**KIRKLEES METROPOLITAN COUNCIL
INVESTMENT & REGENERATION SERVICE**

**DELEGATED DECISION TO DETERMINE APPLICATIONS FOR LISTED
BUILDING CONSENT**

Reference No: 2020/65/90371/W

Site Address: 3, Two Gates, Holme Lane, Slaithwaite, Huddersfield,
HD7 5UG

Drawing number 1106 (PL) 11	A
	rev

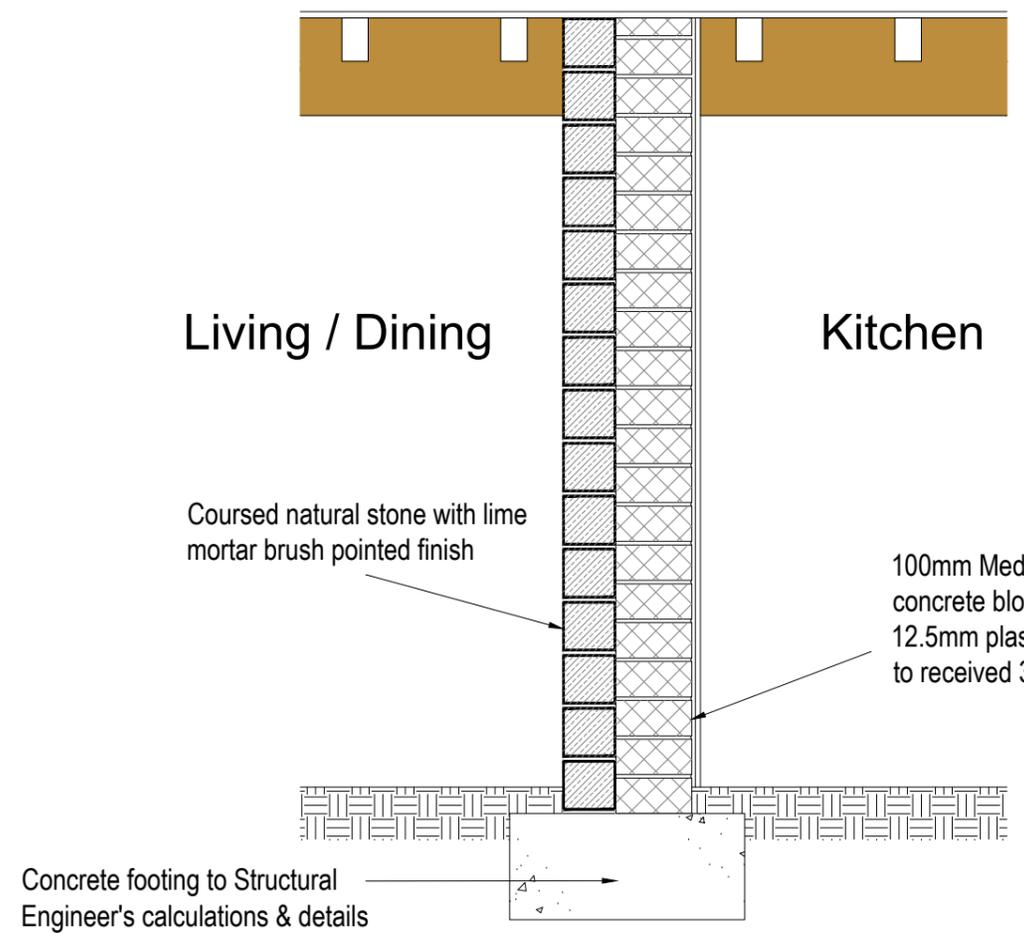
In terms of the alterations to the barn, the alteration of the window on the north east elevation into a full opening would be an enhancement and reveal the original function of the part of the building however concerns were raised regarding the levelling of the ground floor as this would result in the loss of the hayloft and stairs and the replacement of king post truss with a queen post truss would be harmful to the significance of the listed building. This however has been addressed with the submission of an amended plan with additional plans being submitted detailing sections for the proposed first floor and wall sections and window details.

Drawing number
1106 (PL) 03

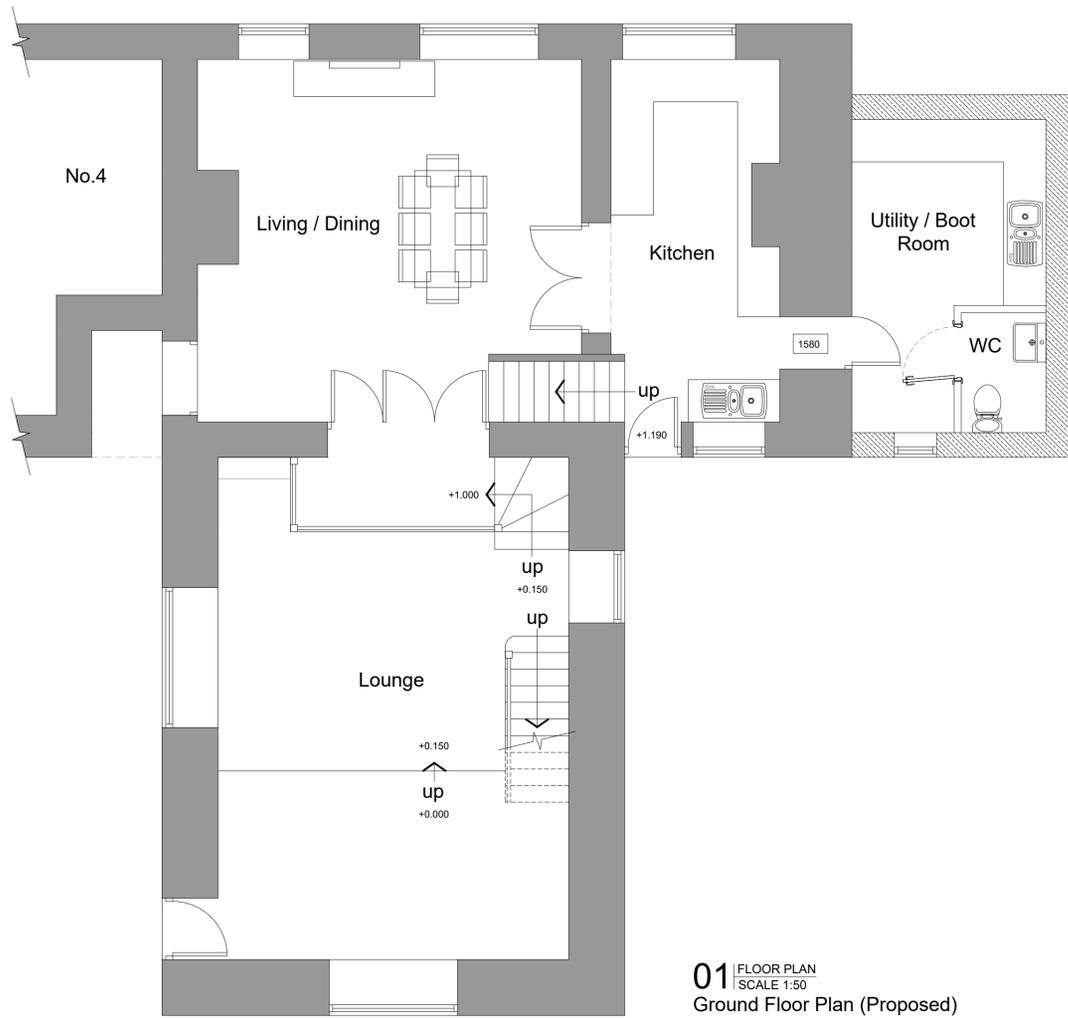
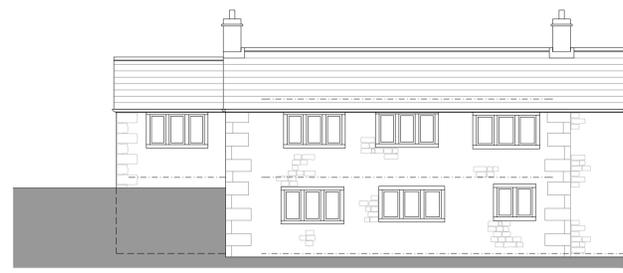
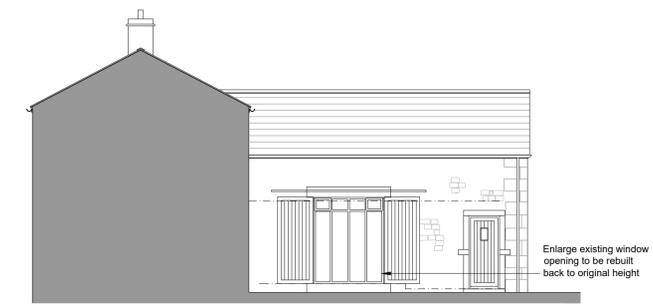
purchased in 2019 then the harm of the internal works undertaken without consent can be largely mitigated. The proposed development largely meets these requirements. To this end, the chimney, to the western end of the building, is to be reinstated to ensure the character of the building is maintained, the details of which are conditioned to make sure the works and materials are acceptable.

3. Prior to occupation of the dwelling, the chimney to the western end of the existing building shall be reconstructed of ashlar masonry. No works to reconstruct the chimney shall take place until a sample of ashlar stone has been submitted to and approved in writing by the Local Planning Authority.

4. Notwithstanding the submitted details the roof to the new extension shall be reclaimed natural stone slate laid in diminishing courses to precisely match the existing roofing materials adjacent in respect colour and texture.

Drawing number	1106 (PL) 12	A
----------------	---------------------	----------

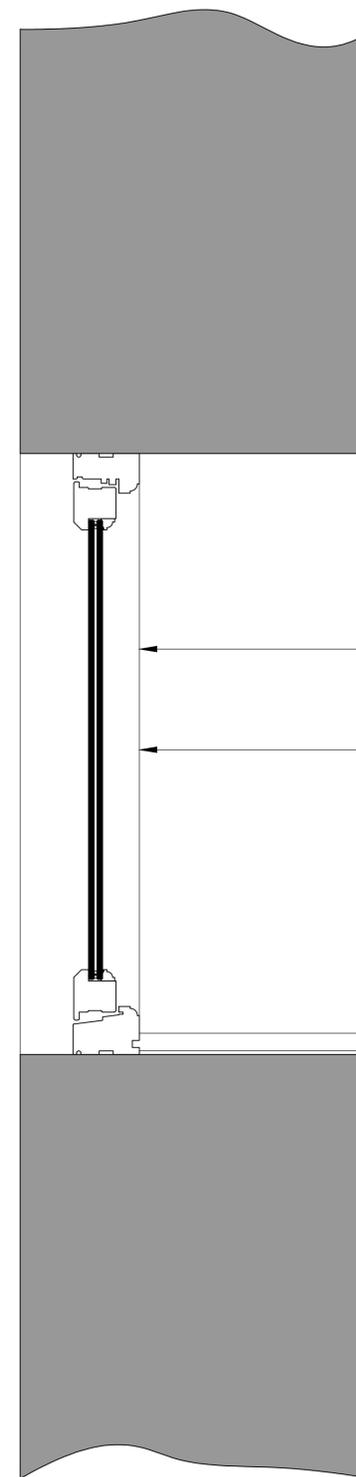
7. The window frames shall be set back in the reveal by 75 - 100mm.

10. Before work begins to install the large windows and sliding timber doors to the former barn, drawings to a minimum scale of 1:20 on elevation and 1:5 on plan and in section fully detailing the replacement windows and sliding timber doors shall be approved in writing by the Local Planning Authority. The works shall be carried out in complete accordance with the approved drawings and so retained thereafter.
